From: Paul Cann
Sent: 21 April 2017 16:37
To: Planning.Responses
Subject: RE: Planning Consultation on: AB/37/17/PL

Drainage engineer comments;

APPLICATION NO: AB/37/17/PL

Description of Works: Demolition of existing dwelling & erection of 1 No. dwelling.

MF 1 Modelled Flood Depths and Levels

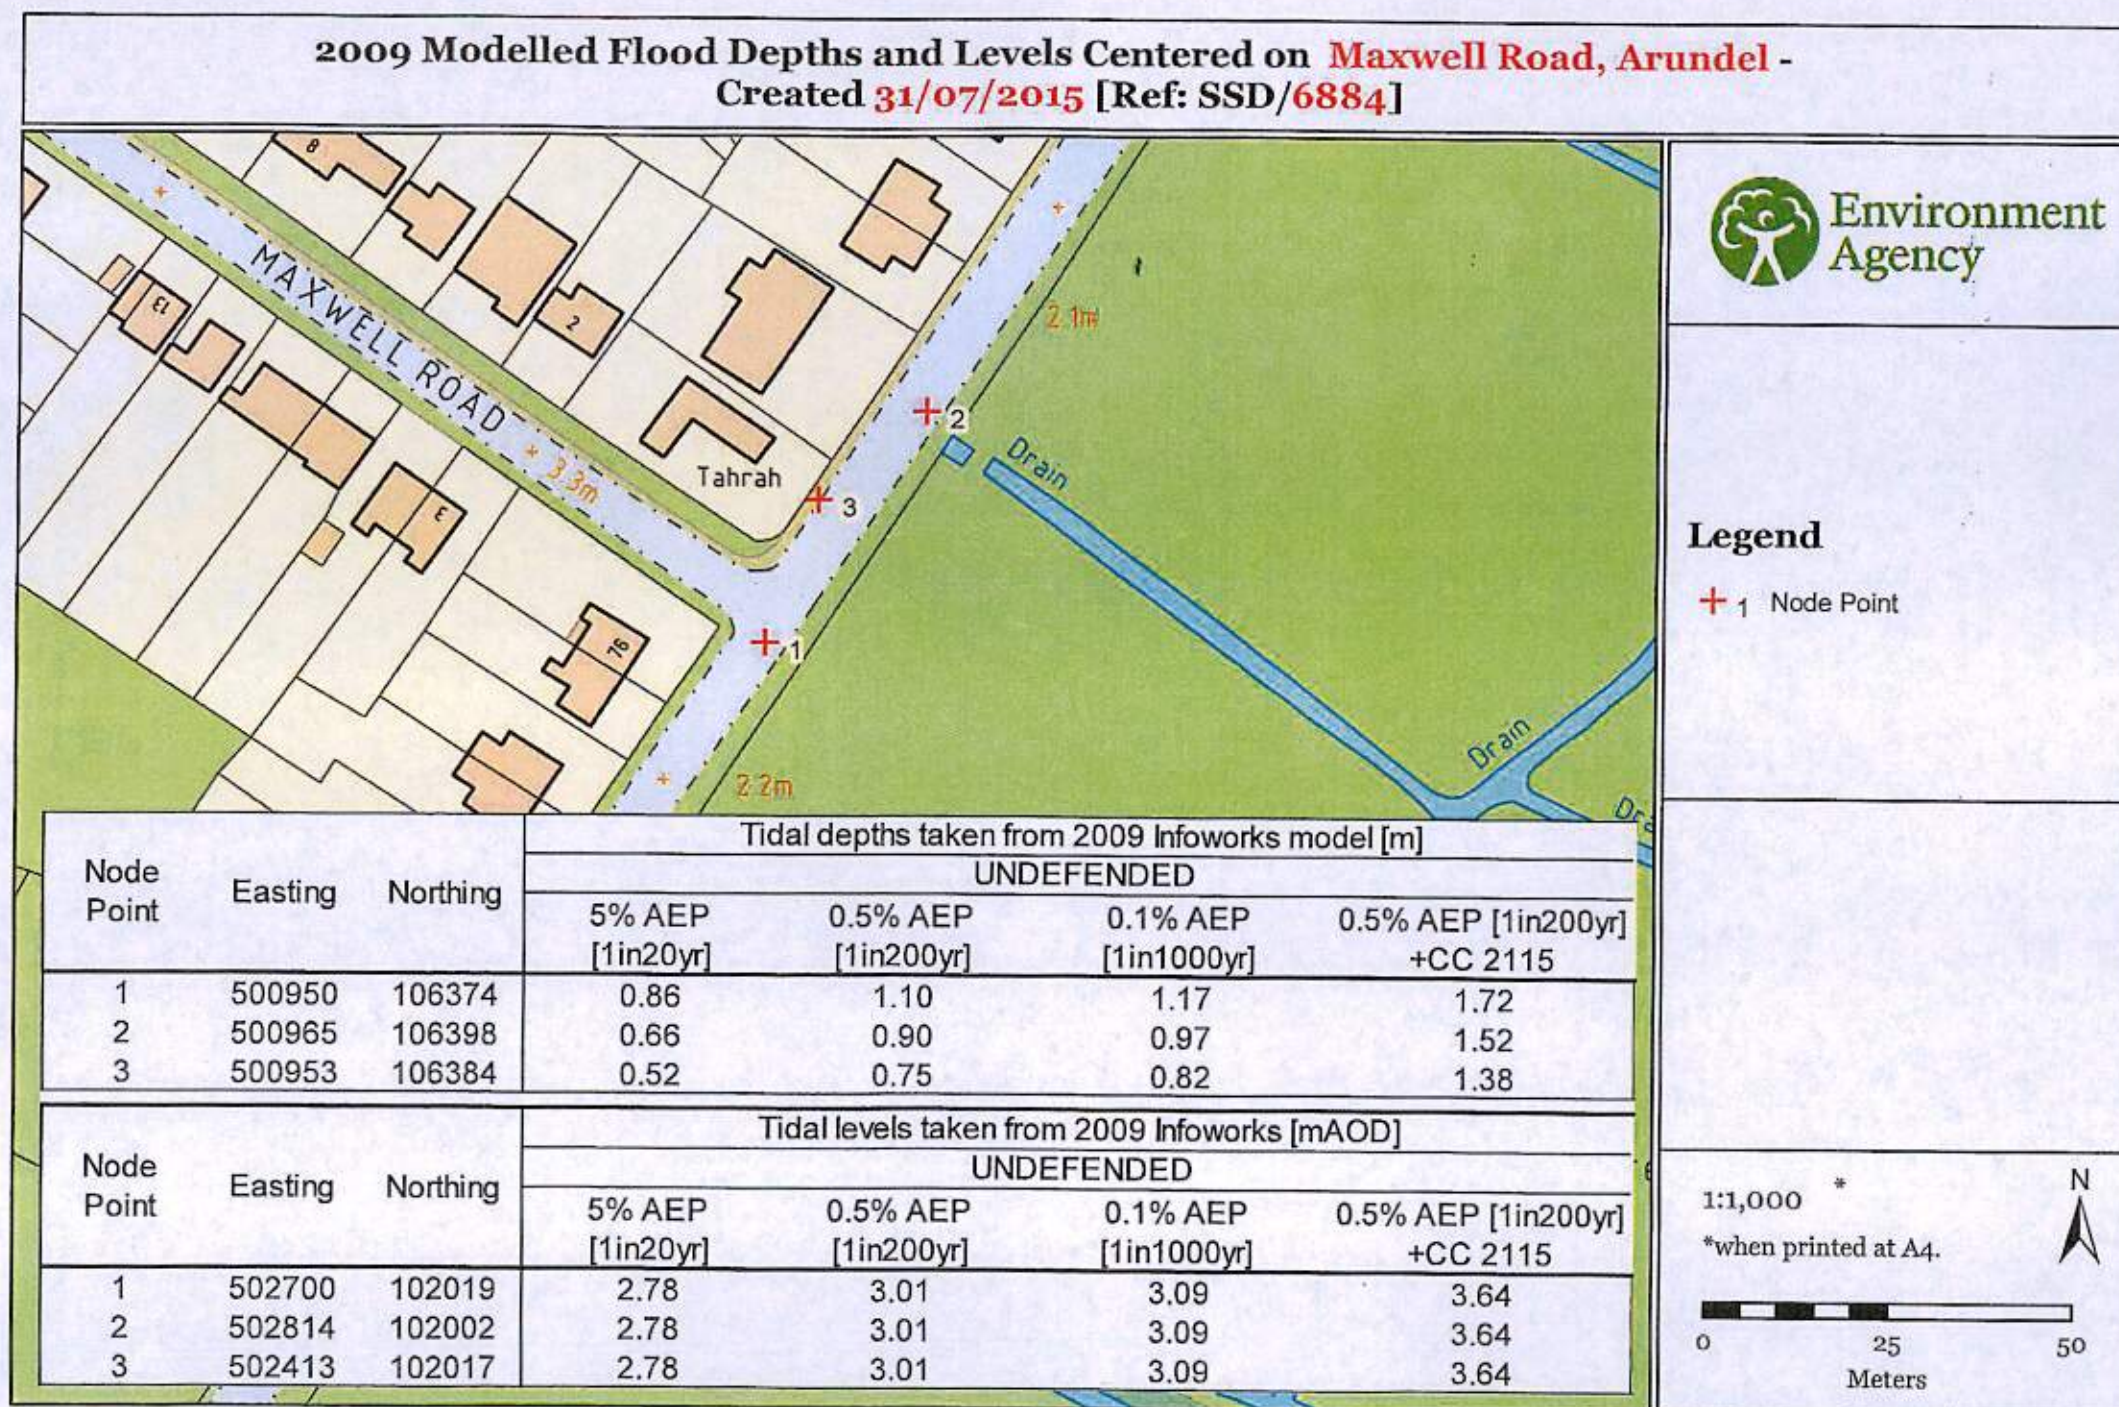
The Environment Agency will need to be consulted in respect to fluvial & tidal flood levels/proposed floor levels, etc.

Site Plan

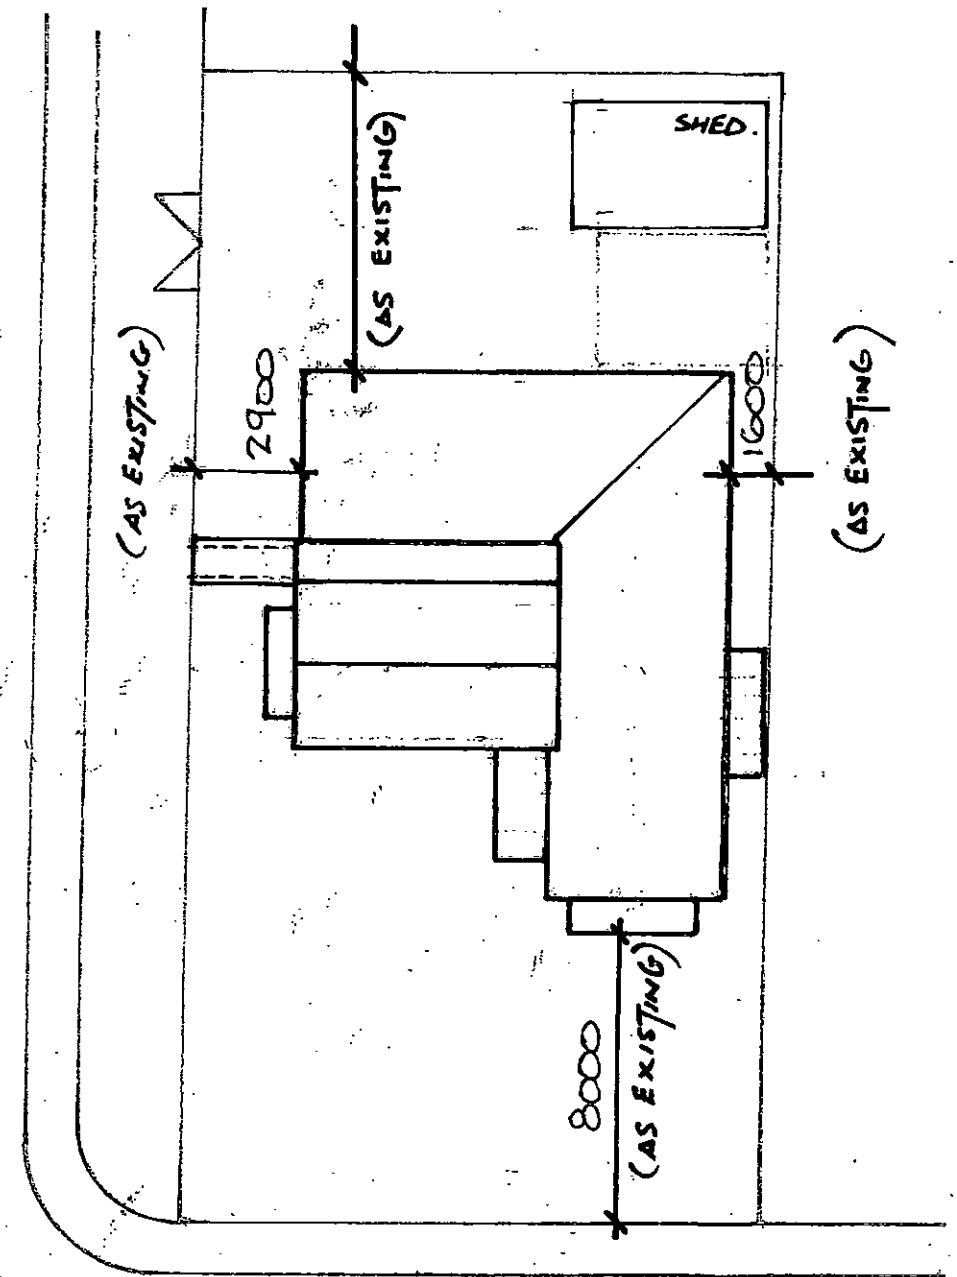
Southern Water need to be consulted as a main public foul sewer crosses the site.

Historical maps indicate that a ditch once crossed the front portion of the site, which may have been subsequently piped. The applicant will need to verify its existence/location, to ensure that it is not affected by the proposals. Please apply standard conditions ENGD4A and ENGD6A. Early discussions with ourselves is recommended.
